**KIRKLEES METROPOLITAN COUNCIL
INVESTMENT & REGENERATION SERVICE**

**DELEGATED DECISION FOR APPLICATION FOR CERTIFICATE OF
LAWFUL DEVELOPMENT**

Reference no.: 2025/CL/91059/W

Description: Certificate of lawfulness for proposed erection of 4
silos adjacent to existing operational building

drawing
Proposed Elevations & Section

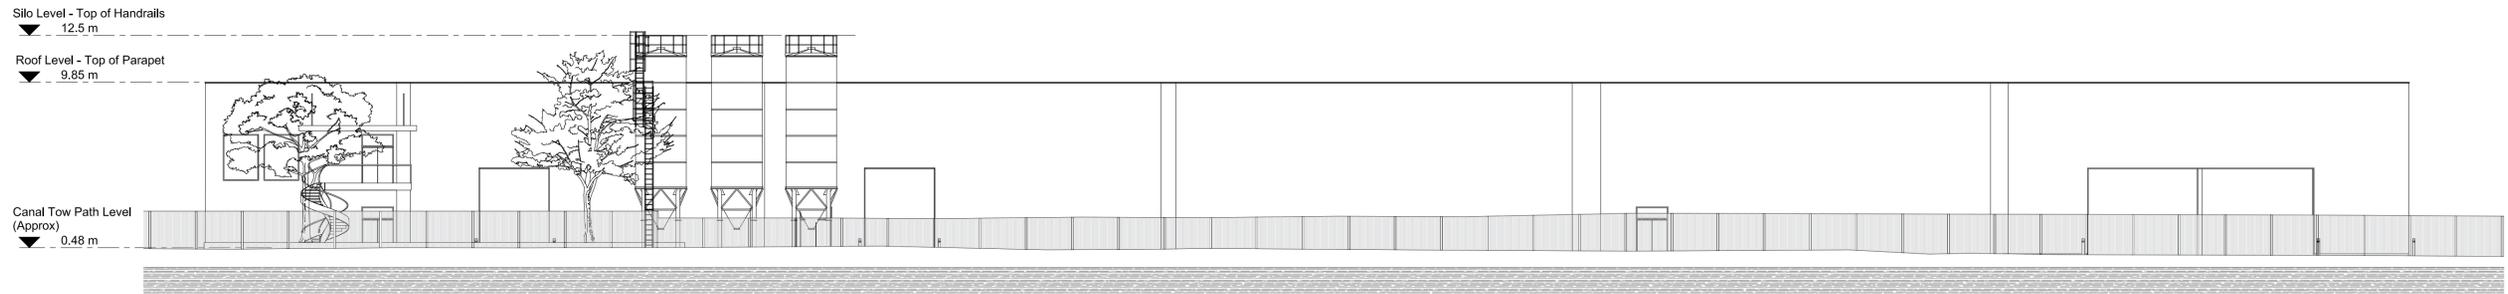
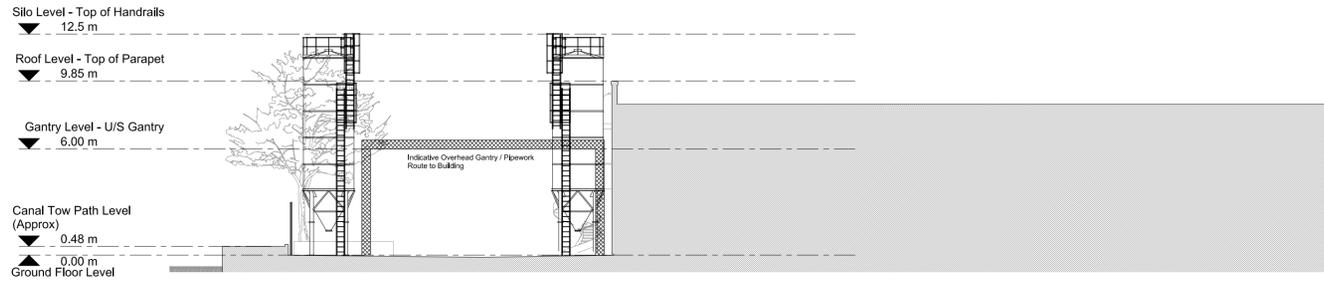
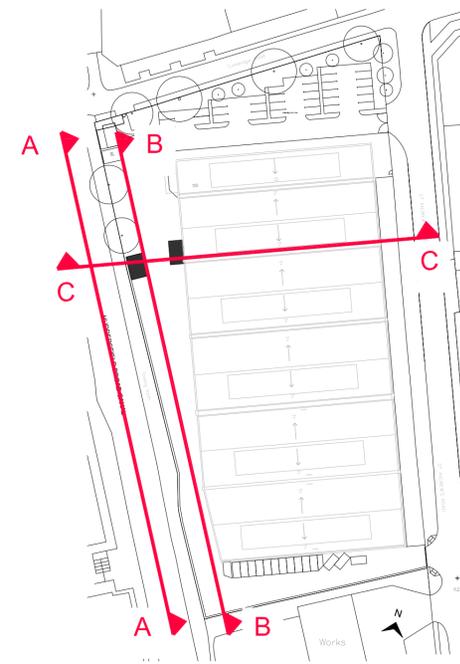
The applicant has provided drawings in support of the application. The drawing no. PL03 - 'Proposed Elevations and Section', does not provide any clarity about the construction material of colour scheme of the silos.

For drawing no. PL03, the drawings: 'Proposed Elevation A – Building' and 'Proposed Elevation B - Canal', have been labelled incorrectly. This does not

hinder the assessment of the proposal, as the information provided in the plan is unambiguous and clear.

The four silos would be sited to the rear of the main industrial building. They are 12.5 metres high, projecting beyond the roof line of the main industrial building by approximately 2.5 metres. They would be significant development altering the roof line of the industrial building and the aspect of the rear west-facing elevation of the premises. The applicant has not provided any information to suggest the appearance of the proposed silos would be mitigated through any colour scheme or “camouflage”.

The four silos are located to the rear of the industrial premises, but there are a number of normal vantage points from which the four silos can be seen¹, to the south-west from the car park of Sainsbury’s and to the north / north-west from Turnbridge Road. The vantage point along Turnbridge Road in particular, which is a frequently used highway between St Andrew’s Road and the Ring Road, is less than 50 metres from the proposed four silos and viewed from there, would materially affect the external appearance of the premises.

It is noted that the industrial premises has landscaping in the form of grassed areas and trees along the north and north-west boundary which to a degree would ameliorate the visual impact of the premises on the area. However, the four silos would remain prominent development given the height, location and scale in proximity to the public realm and therefore would materially affect the external appearance of the premises and the impact of the landscaping.
